Application Reference: 6/2017/1486/VAR
Proposed development at: Unit 13 Peartree Farm Welwyn Garden City AL7 3UW.
Proposal: variations of condition 1 (approved plans) on planning permission 6/2015/1960/FULL.

I wish to object to the above proposed development. I consider that the modified plans are considerably different from those previously approved.

FIRST FLOOR PLAN

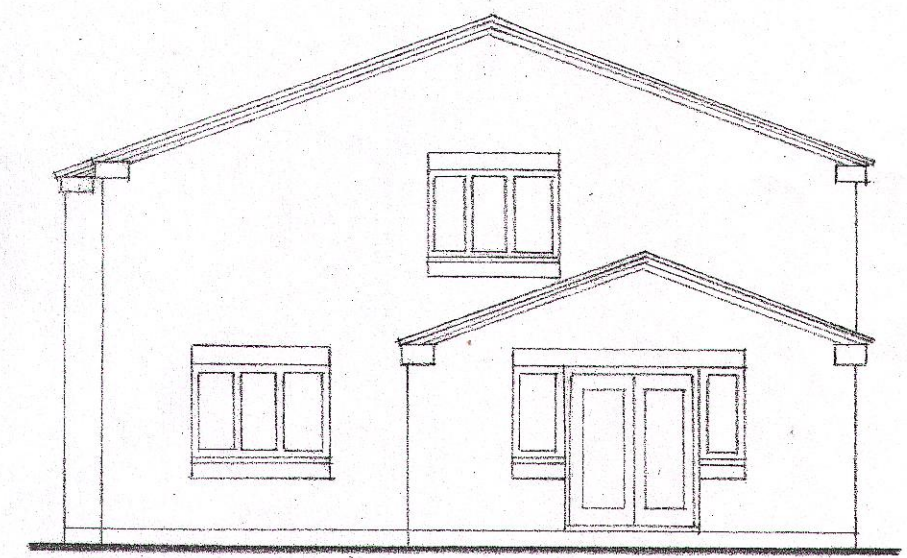
My primary objection is the change to the first floor of the building. The previous plan composed of a building of one and half storeys. With the addition of height to the east wall and the additional windows on the first floor this will in effect become a two storey building. This will be entirely out of character with the other industrial units of Peartree farm and severely impact the amenity of my rear garden.

EAST ELEVATION

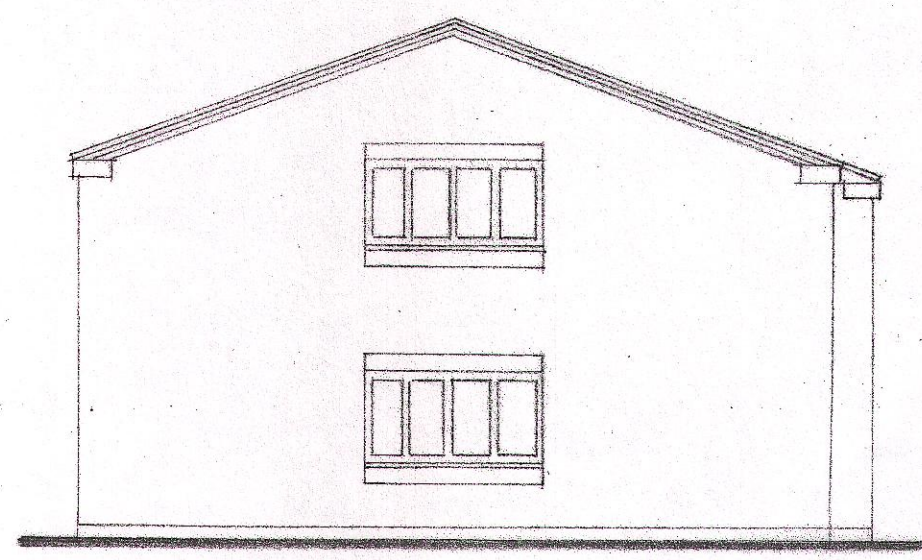
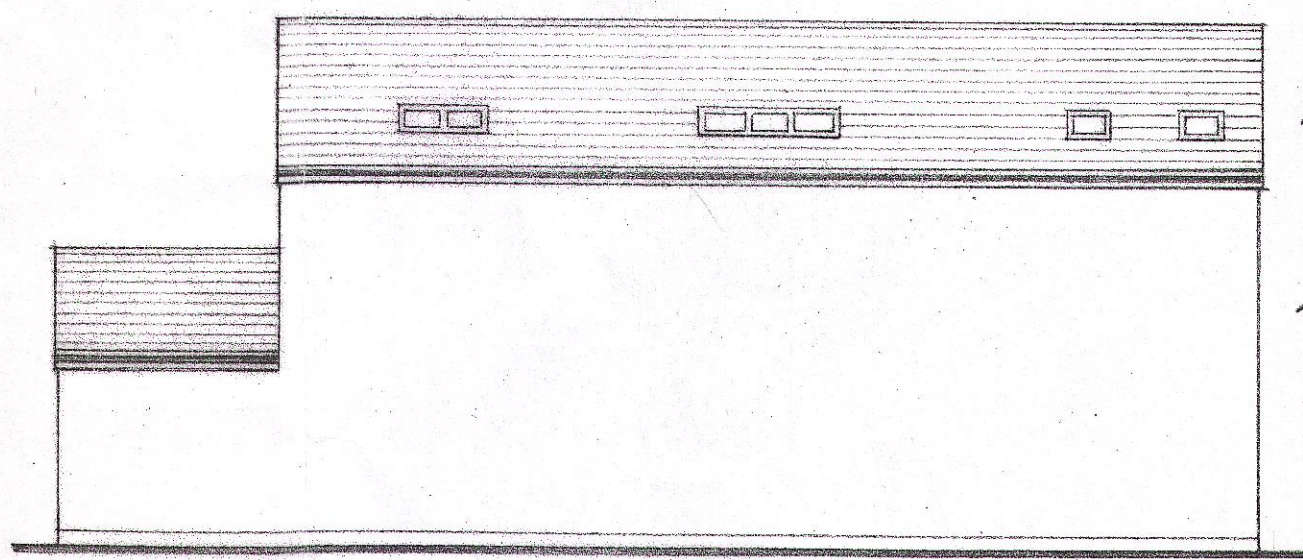
I am also concerned by the proposed new proposed position of the development closer to my boundary. The building will be directly adjacent to my property which is further detrimental to my amenity.
